28 July 2015

RE: MP 08_0222 MOD 6 - Global Switch, City of Sydney Comments

drawing title
Level 0 Floor Plan

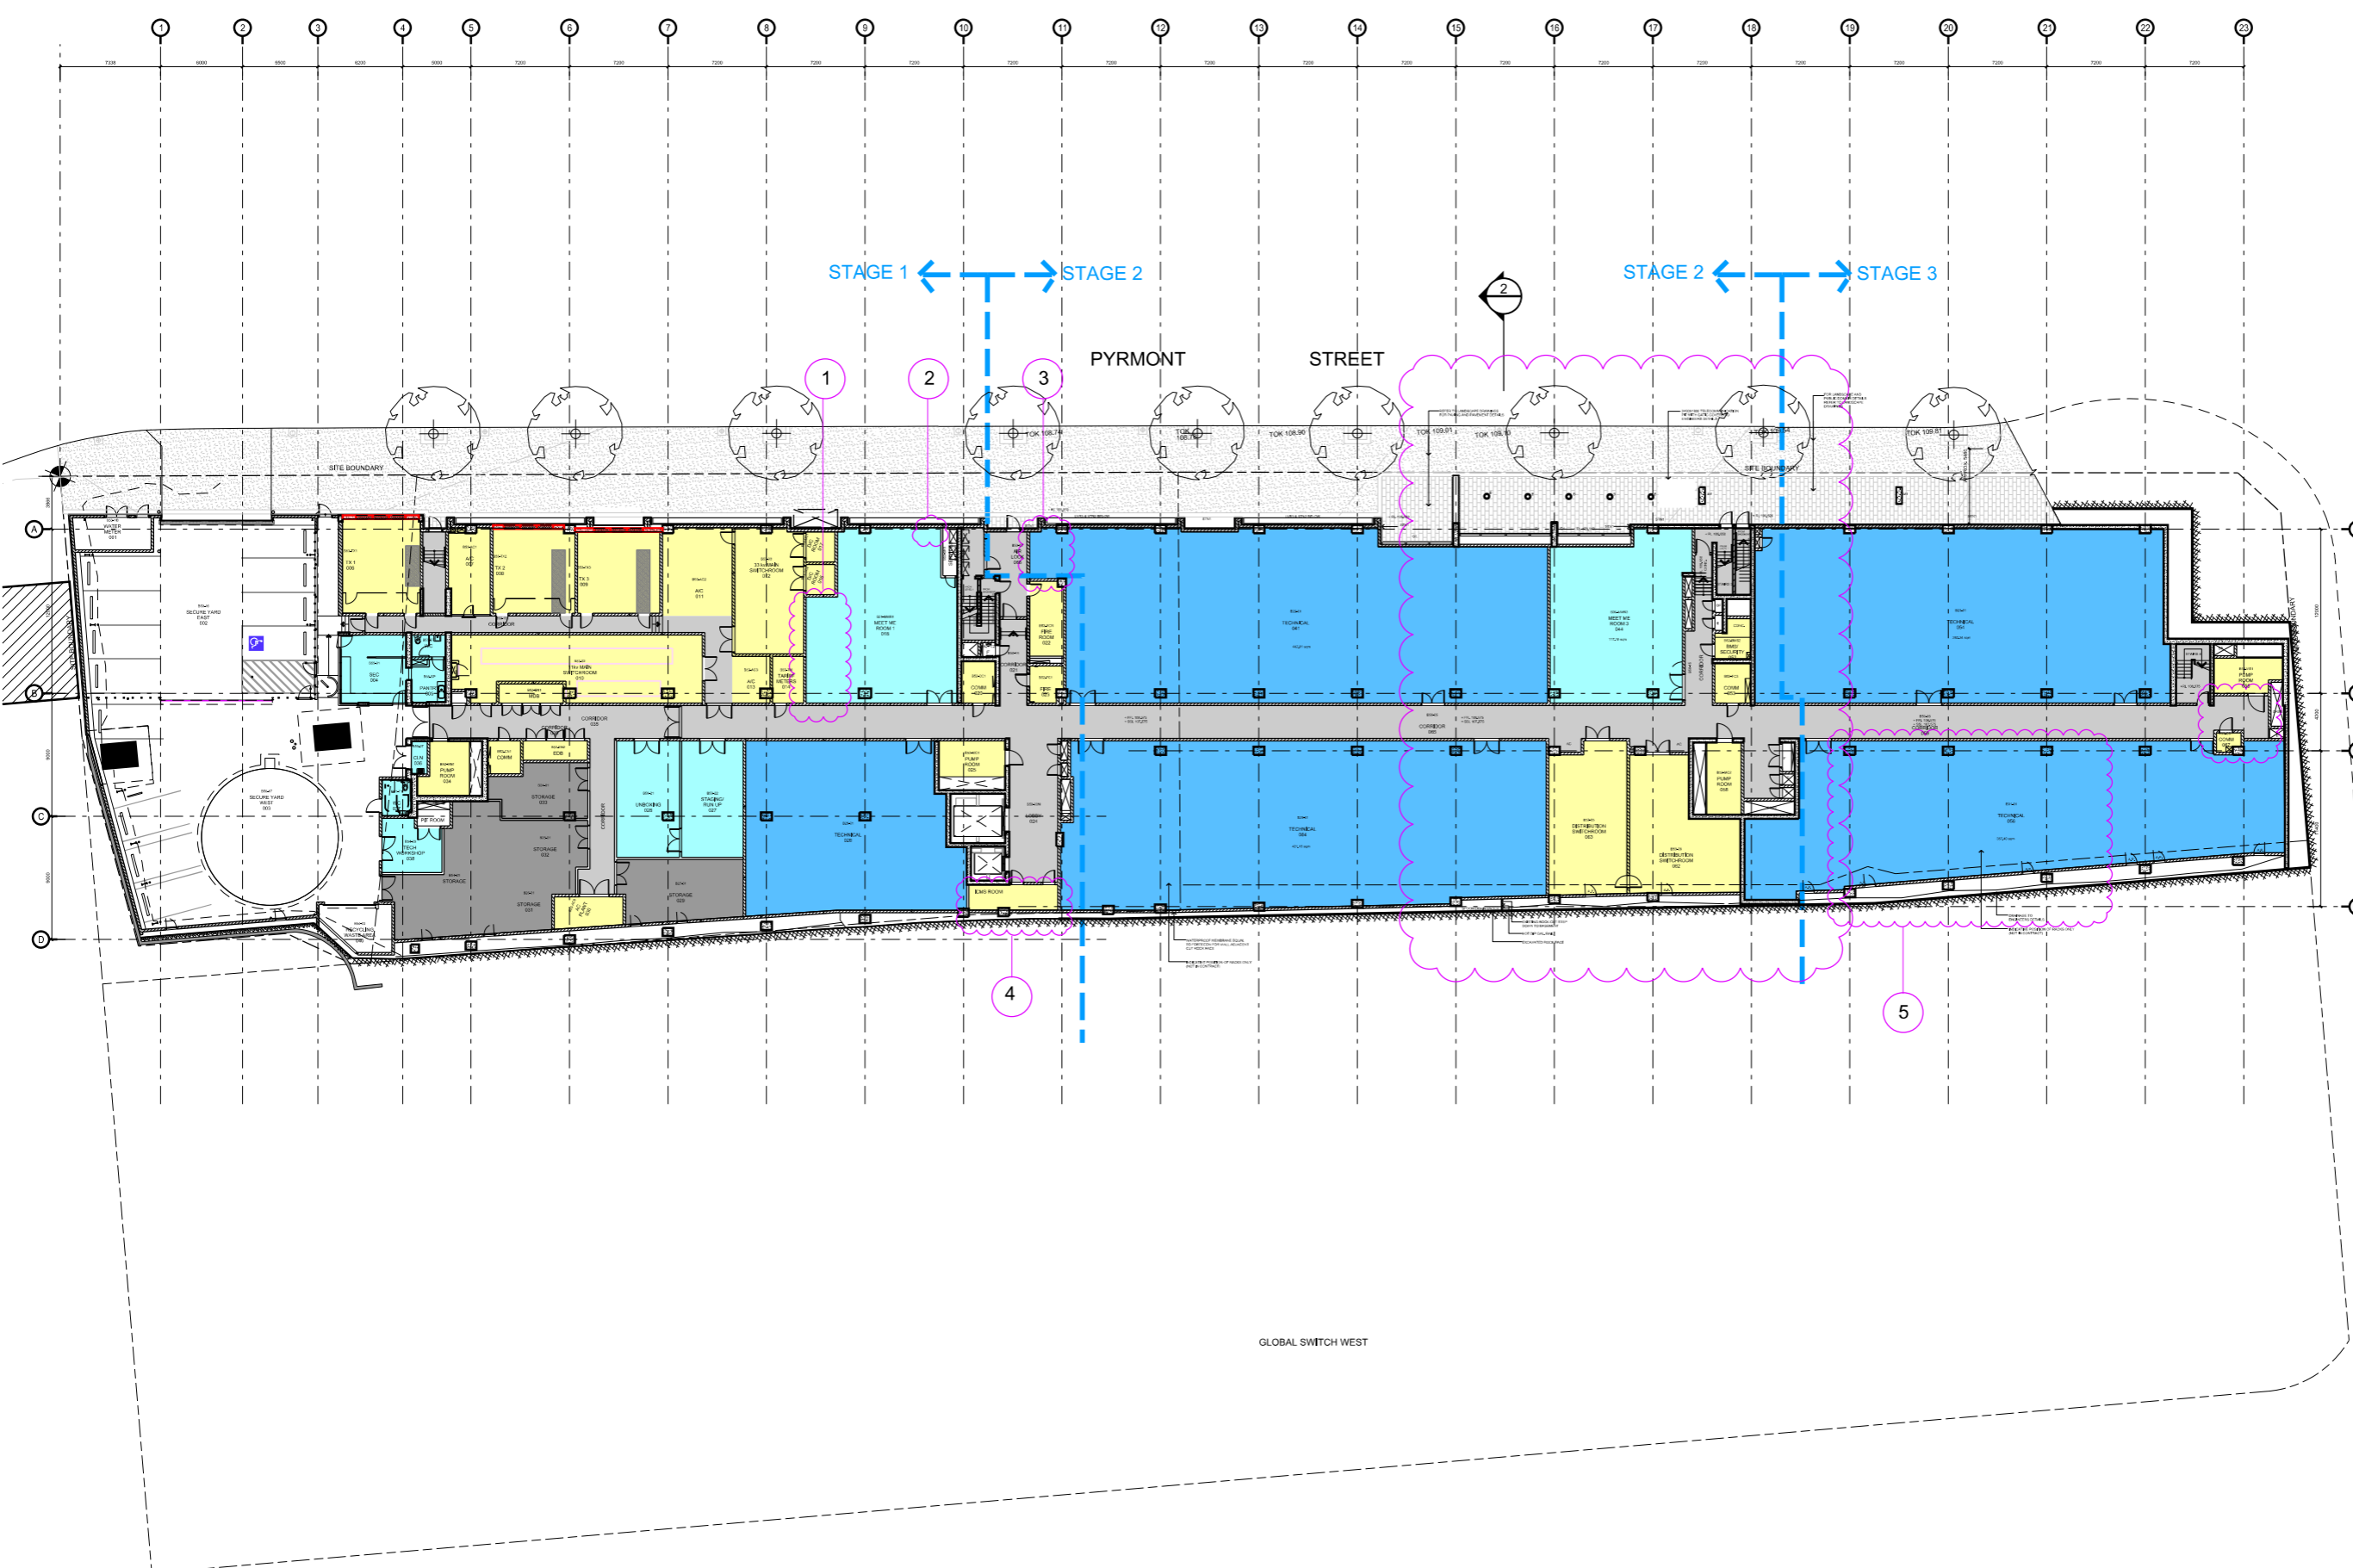
Global Switch owns, manages and operates data centres around the globe and all of its facilities operate at the highest levels of security in order to maintain the optimum environments for the IT equipment housed within the buildings. It should be noted that the "Meet Me Room" on Pyrmont Street (referred to in the City's comments) is not a conventional meeting room, but rather it is a technical space containing sensitive communications infrastructure. Accordingly, it is not possible to have a glazed and fully transparent frontage to this space for operational and security reasons.

Global Switch recently completed the first stage of its \$250 million Sydney East expansion. Integral to this project has been the upgrading of its main entry and access to the campus on Harris Street in response to a change in the business operations. This upgrade has allowed for an enhanced entry into both the existing Sydney West and new Sydney East, and provides a seamless operation for visitors. In undertaking these works, it was determined that the original entry on Pyrmont Street was no longer required to operate as an entry point and reception area. Rather than confuse visitors to the premises, the second point of entry on Pyrmont Street is therefore proposed to be deleted and the internal floor space converted into usable technical area.

drawing title
East Elevation

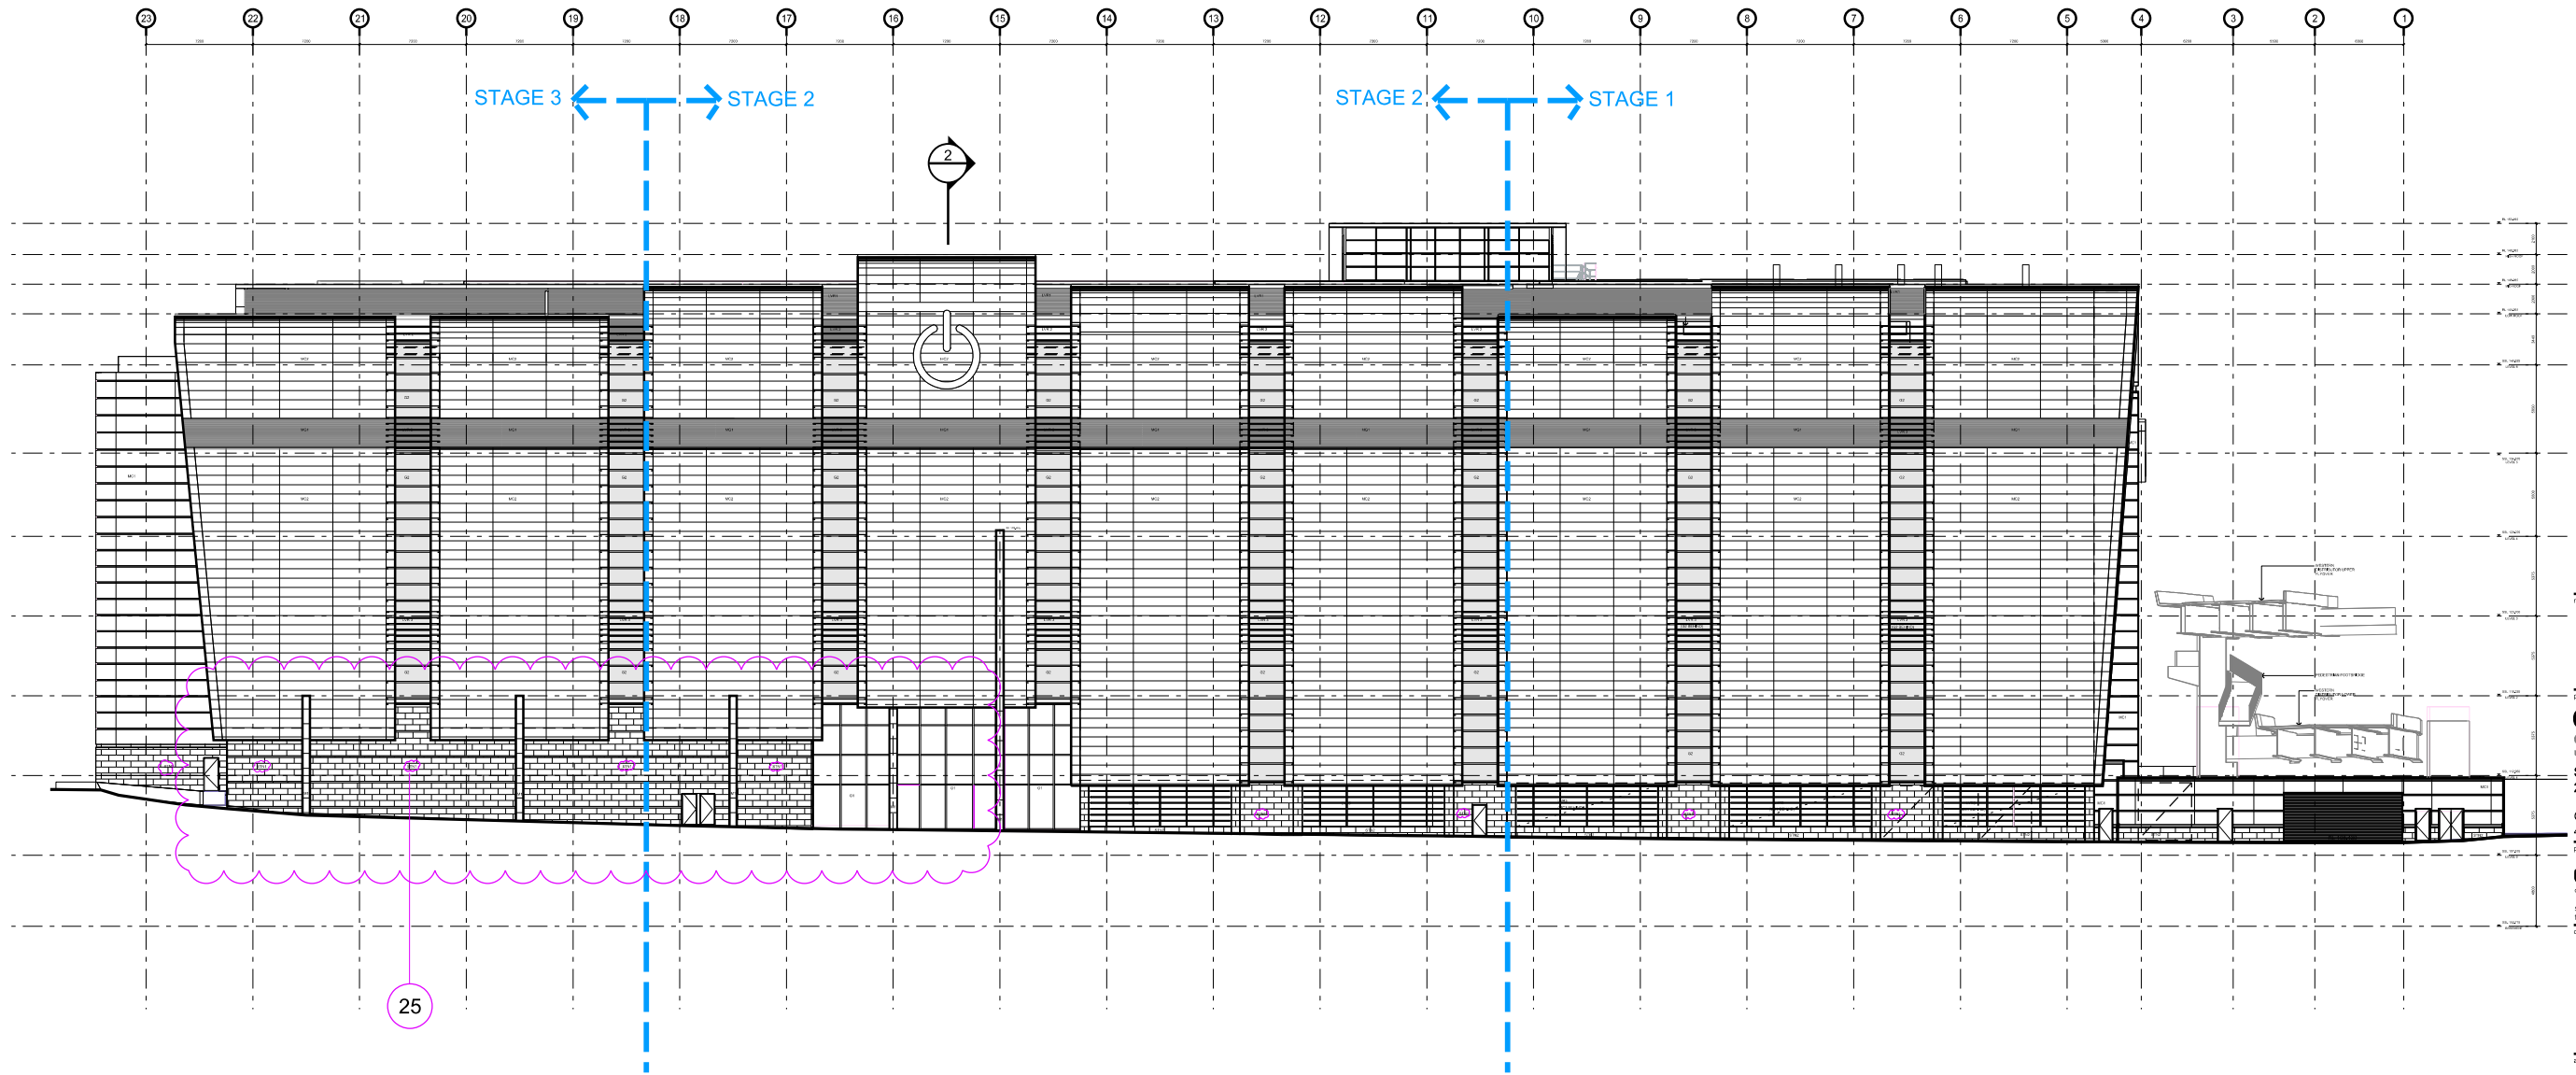
The City has also raised concerns about the blade columns at ground level, due to lack of surveillance of the area. Global Switch considers that it is important to maintain the integrity of the approved Pyrmont Street façade, which includes the rhythm created by the blade walls. As stated above, by necessity Global Switch operates in a highly secure environment. Accordingly all parts of the building, including its perimeter, are fully covered by external CCTV and lighting is provided for both illumination and security purposes.

The future façade treatment to replace the Pyrmont Street entry will be designed to respect the architectural treatment, whilst creating interest / activation in the streetscape in response to the City's concerns.

Based on this advice, Global Switch is prepared to accept a condition which requires the Pyrmont Street facade treatment to be resolved and approved prior to issue of the "relevant Construction Certificate".
